DeYOUNG SUBDIVISION Construction Drawings El Paso County, Colorado

EPC STORMWATER REVIEW COMMENTS ARE SHOWN IN ORANGE BOXES WITH BLACK TEXT

PCD-ENGINEERING REVIEW COMMENTS IN BLUE BOXES WITH BLUE TEXT

PCD PROJECT NO. MS-20-001

HORIZ. SCALE: 1"=40'
 VERT. SCALE: N/A
 SURVEYED: RIDGELINE
 CREATED: 10/11/19
 PROJECT NO: 031901
 SHEET: C1.1

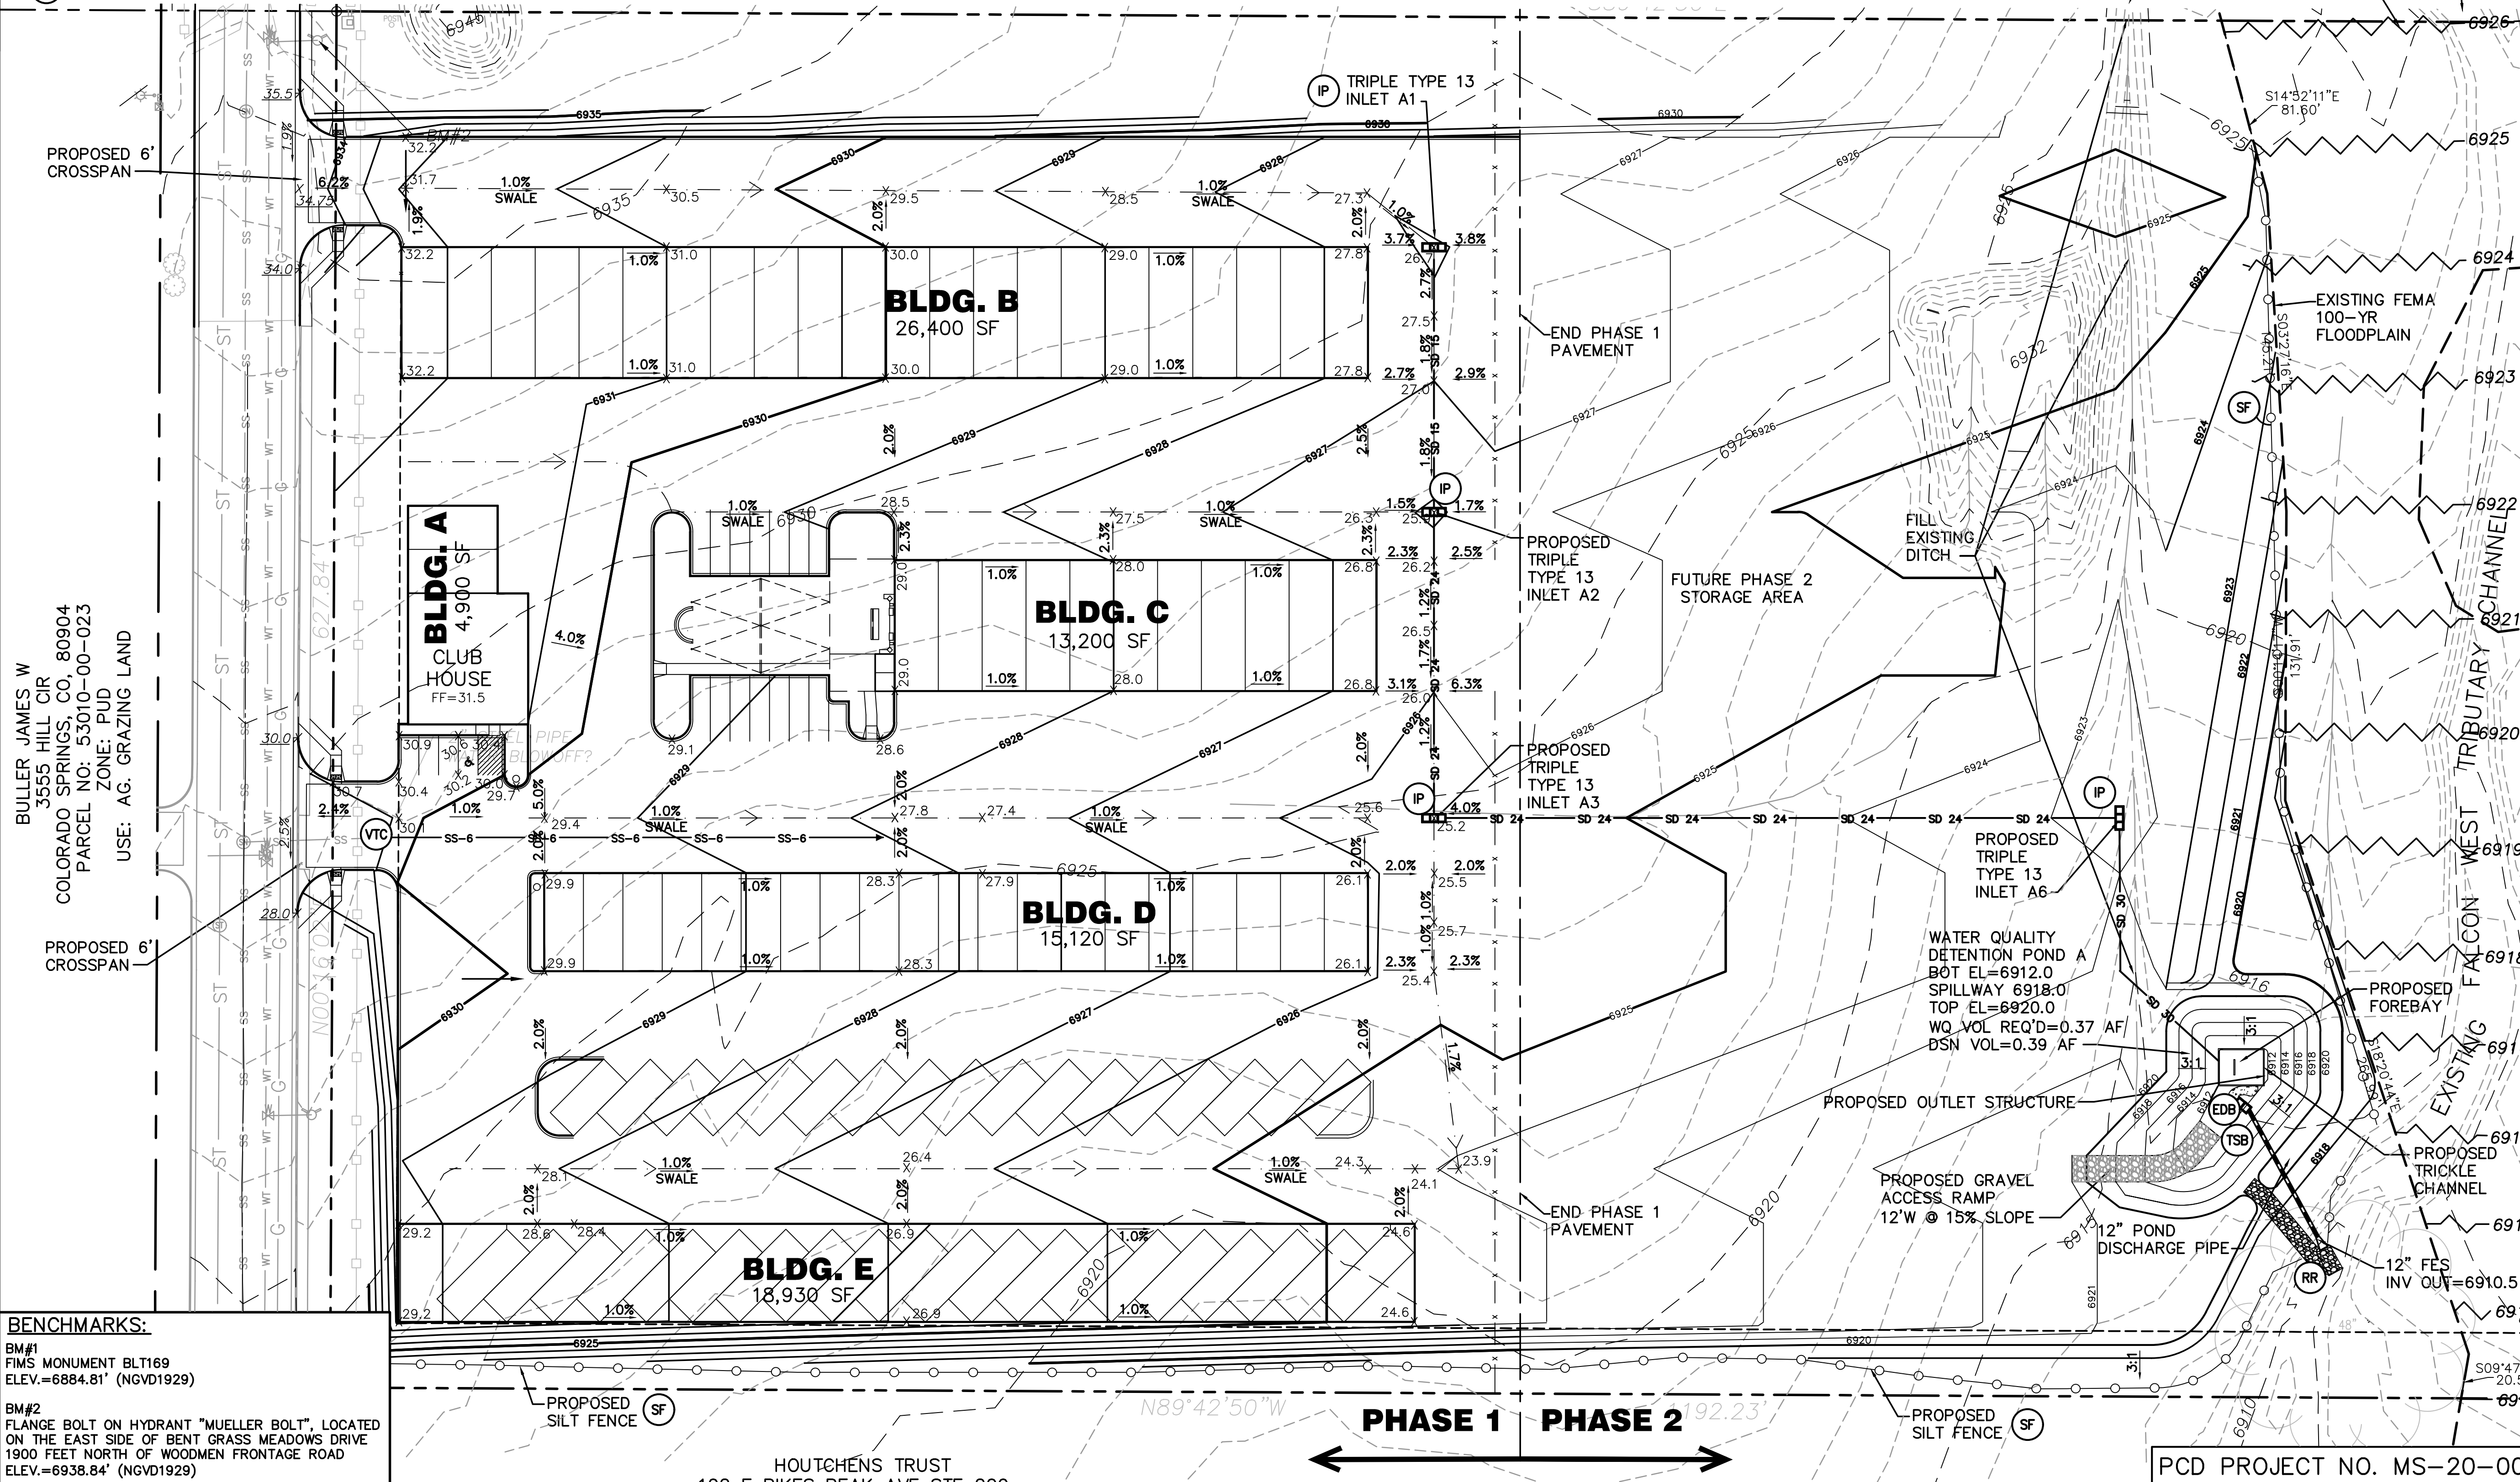
Is this a raised island?
Don't show parking spaces
